From: Amanda Scholes <Amanda.Scholes@arun.gov.uk> **On Behalf Of** Planning.Responses
Sent: 10 December 2019 08:53
To: Anita Gardner <Anita.Gardner@arun.gov.uk>
Subject: FW: 10053: Toddington Lane Littlehampton, Arun District, BN17 7PN APP/C3810/W/18/3197149 (LU/162/17/PL) Condition 14

Subject: 10053: Toddington Lane Littlehampton, Arun District, BN17 7PN APP/C3810/W/18/3197149 (LU/162/17/PL) Condition 14

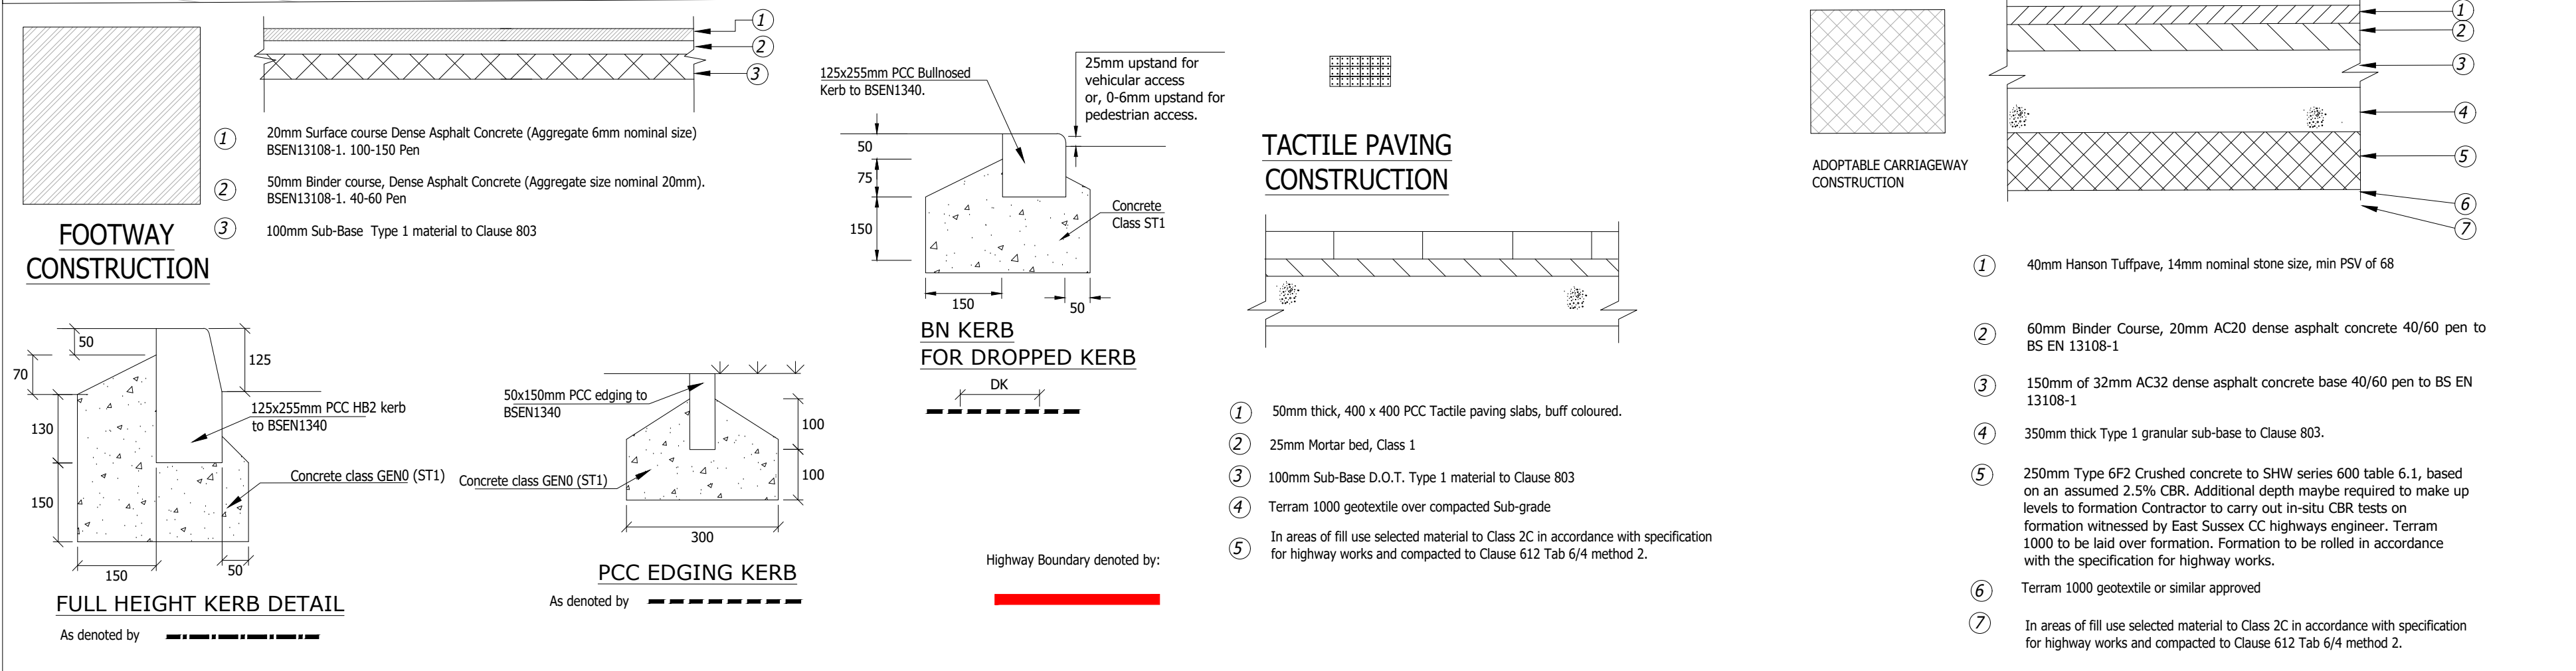
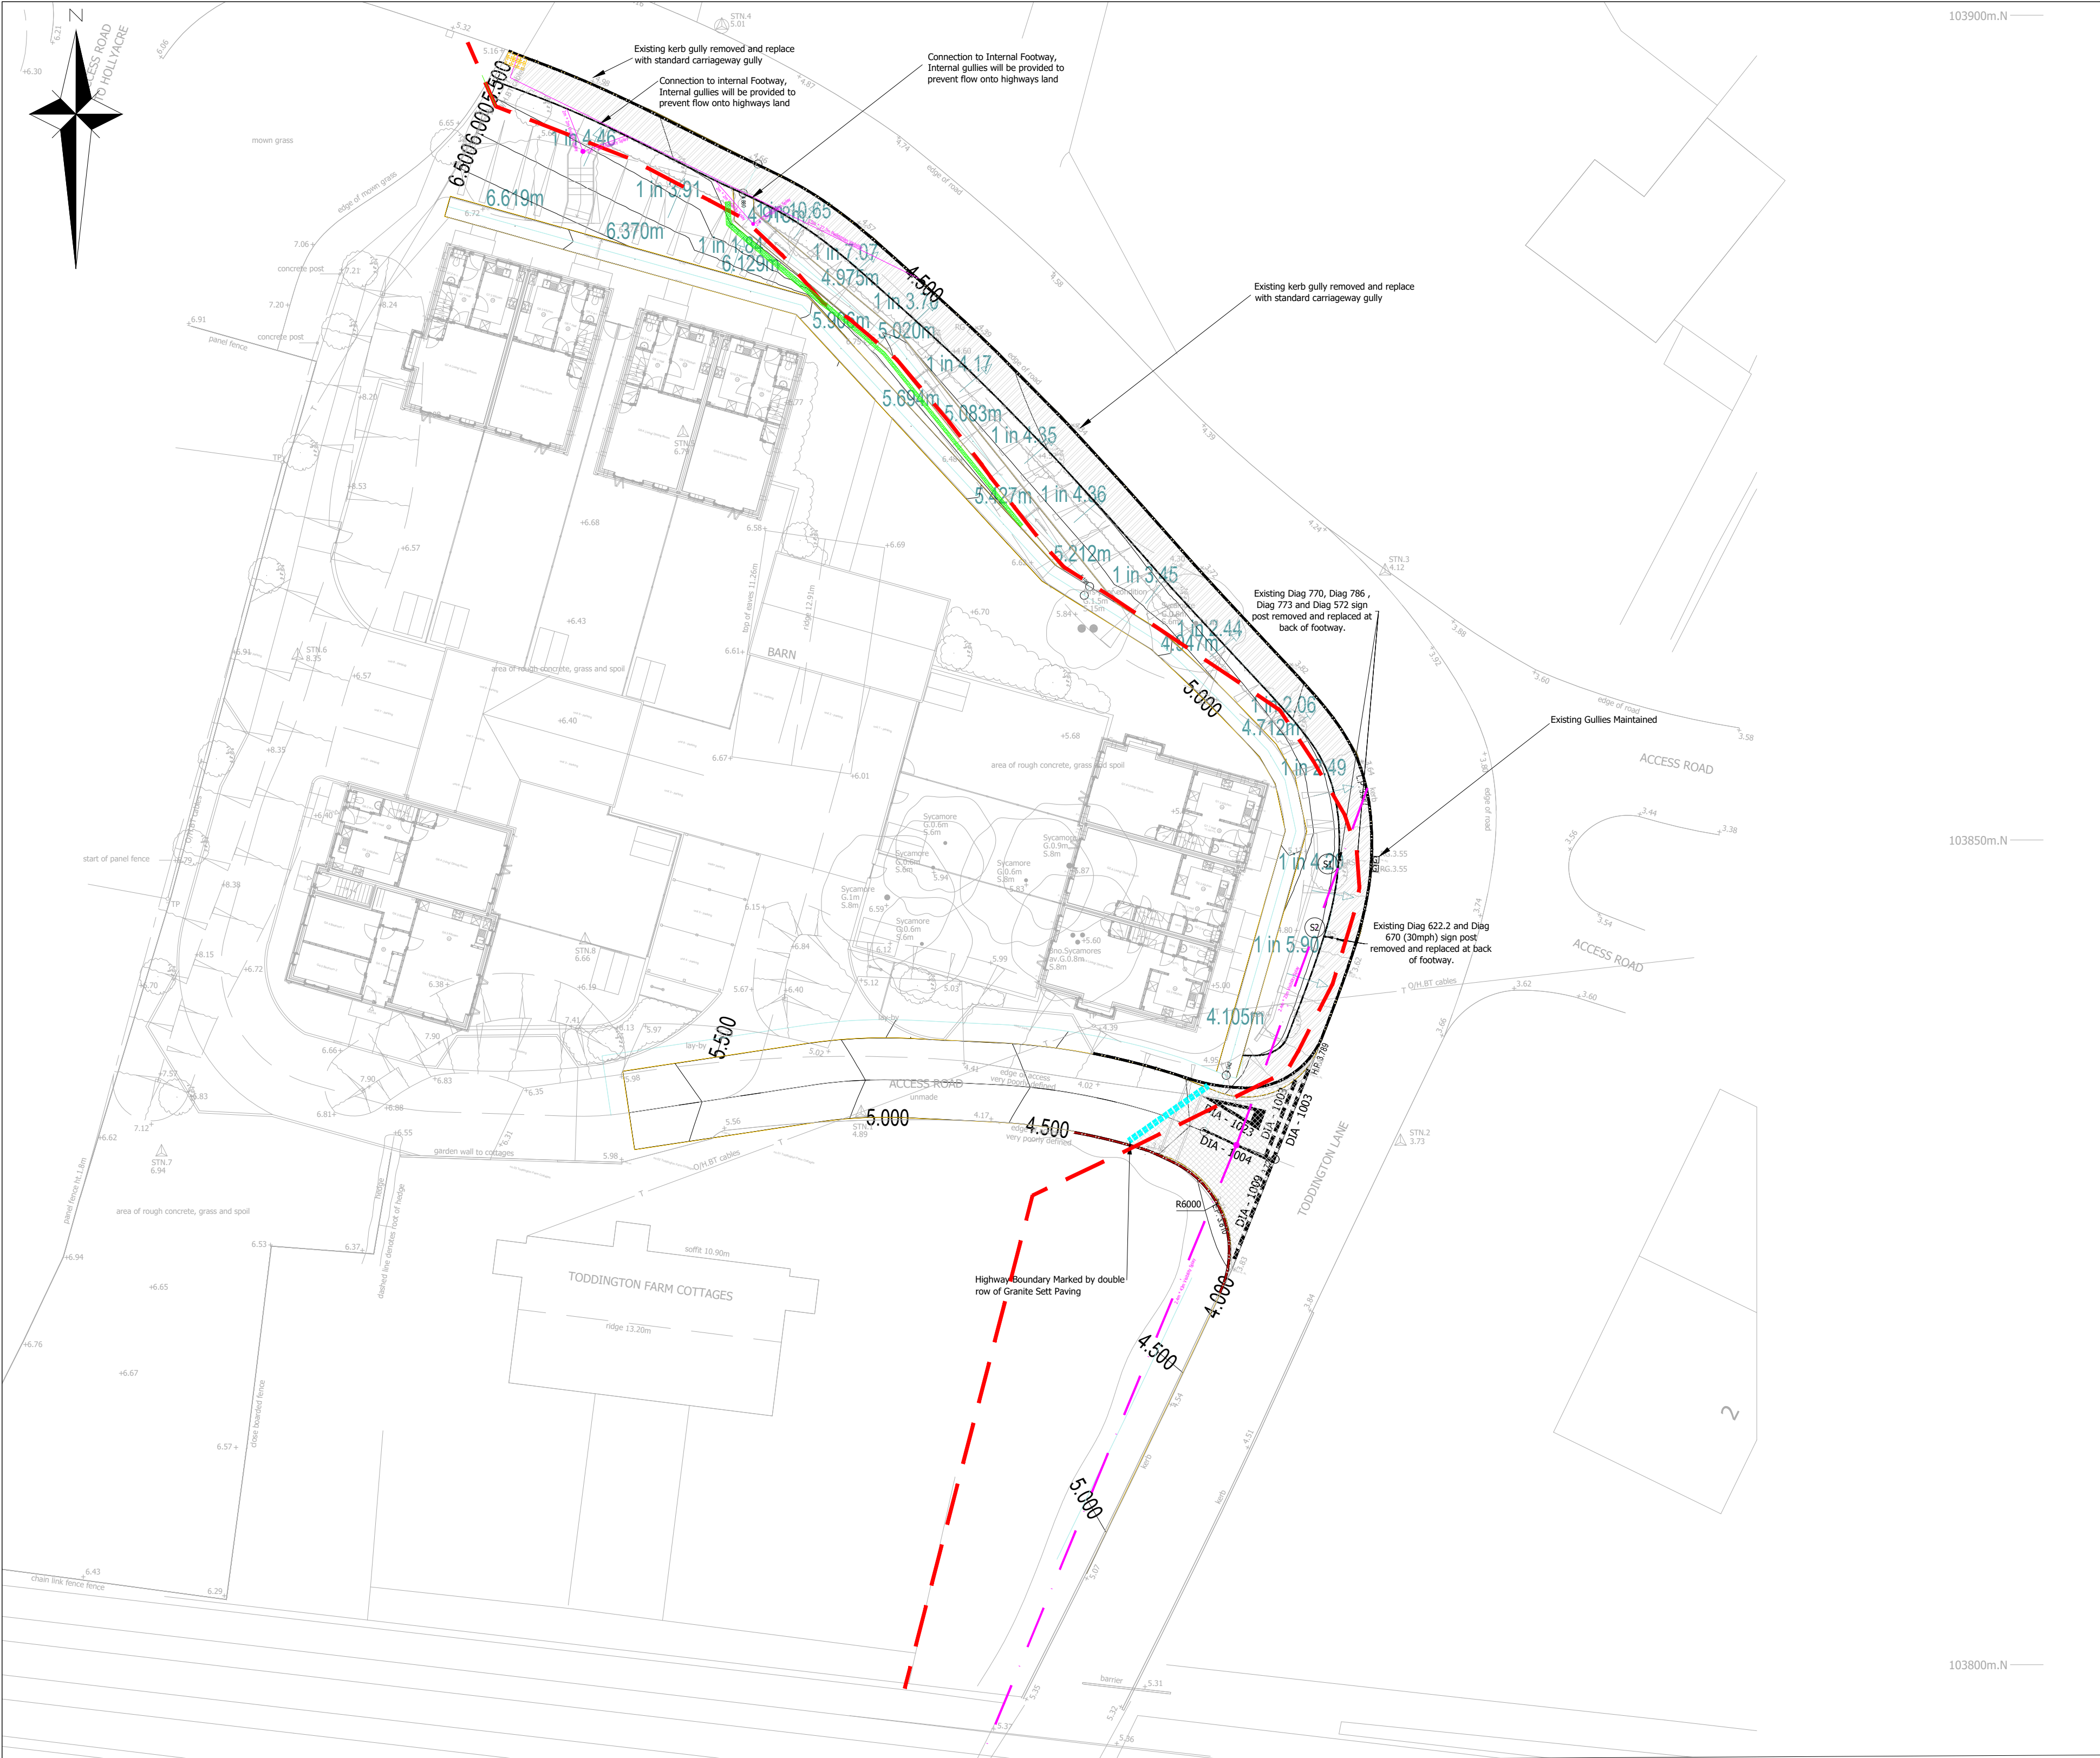
I am contacting you in regards to the development at Toddington Lane (LU/162/17/PL) and condition 14. In your comments on 15th October 2019 you asked for A visibility splay of 2.0m * 66m in both directions at the western end of the proposed footway. This was to ensure any pedestrians crossing in this location have sufficient visibility to see any oncoming cars. The 66m visibility splay is achievable looking west but not looking east.

I note that section 4 of WSCC design guide states that lightly trafficked residential roads have 85thile speeds below 37mph, can have MfS1 standards applied. As this is the case for Toddington Lane, the 66m visibility splay is likely in excess of the stopping sight distance for westbound vehicles will need to see pedestrians. Using MfS1 standards and the recorded 28mph 85thile speed there is a stopping sight distance requirement of 39m.

I also note that the visibility splay asked for is from 2.0m, the proposed footway is 2m in width and it is unlikely a pedestrian would be stood on the back edge of the footway, would a visibility splay from 1.0m be acceptable as this is likely to be more reflective of a pedestrians position on the footway.

With the above in mind I would suggest a 1.0m * 39m visibility splay should be acceptable and allow for the crossing point to function safely. Please see update site layout with the visibility splays, I have shown 66m looking westwards as this is achievable and 39m is achievable looking east. Please note I have shown the 39m visibility splay to 600mm off of the kerb to represent the likely position of a car.

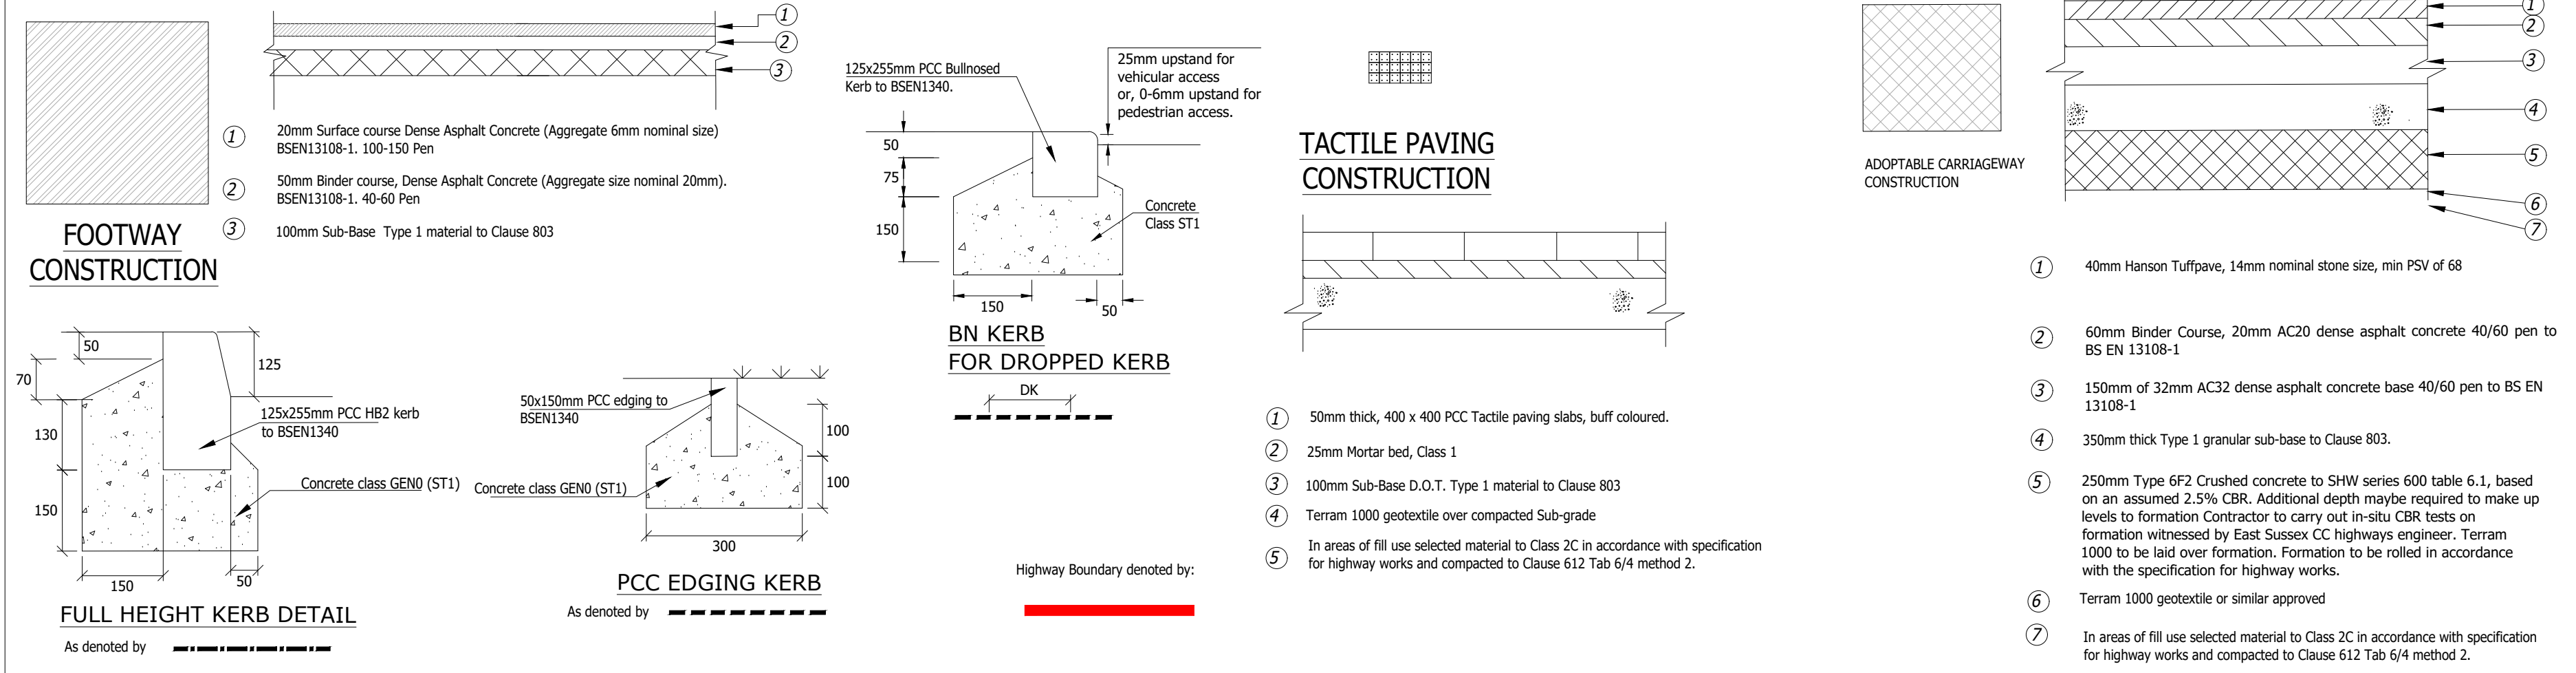
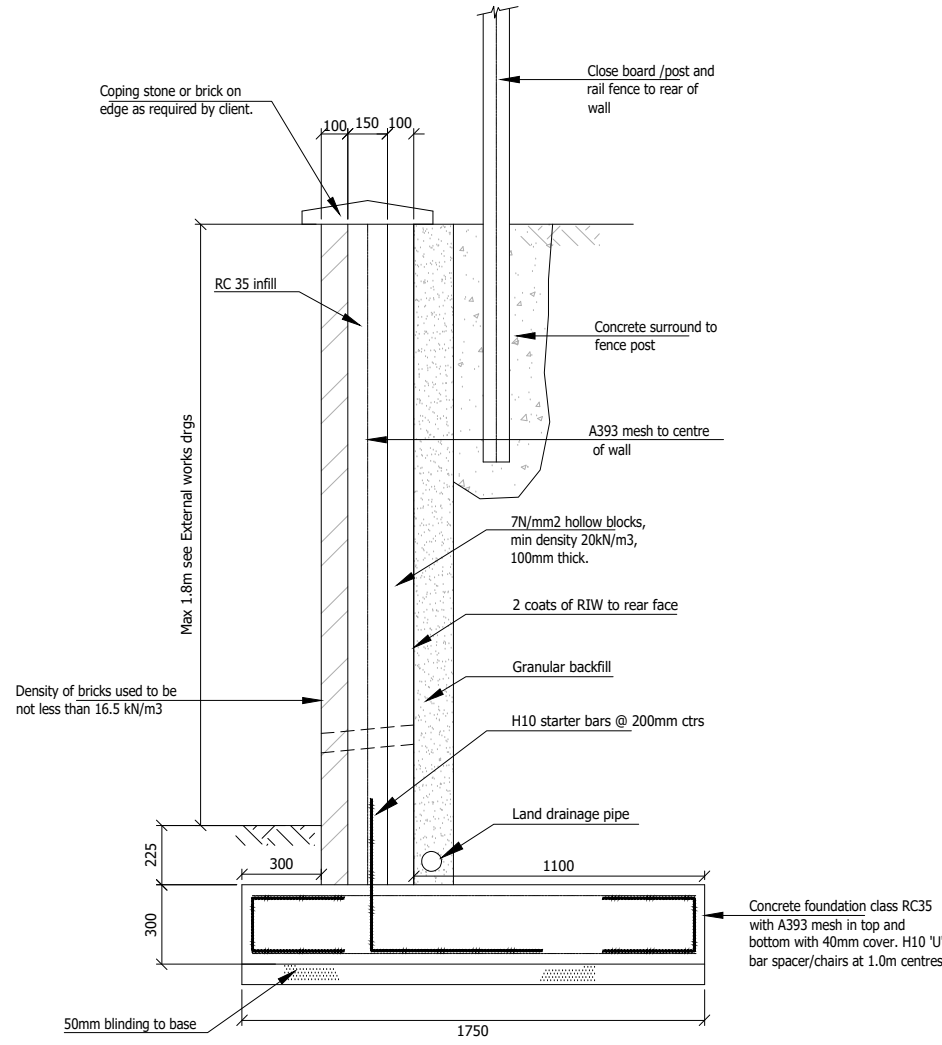
In principle I think we could accept the 1 metre. However just one point I would like to confirm, the 66 metre splay to the west can you confirm in a bit more detail it is all contained within highway land as it present it is not stated.

In order to ensure that the visibility splay looking west is entirely within highways land we can only guarantee a 59m visibility splay. In regards to this I would refer to my email to Tim from 19th November:

As such I would contend the 59m visibility splay entirely within the highway boundary should be acceptable.
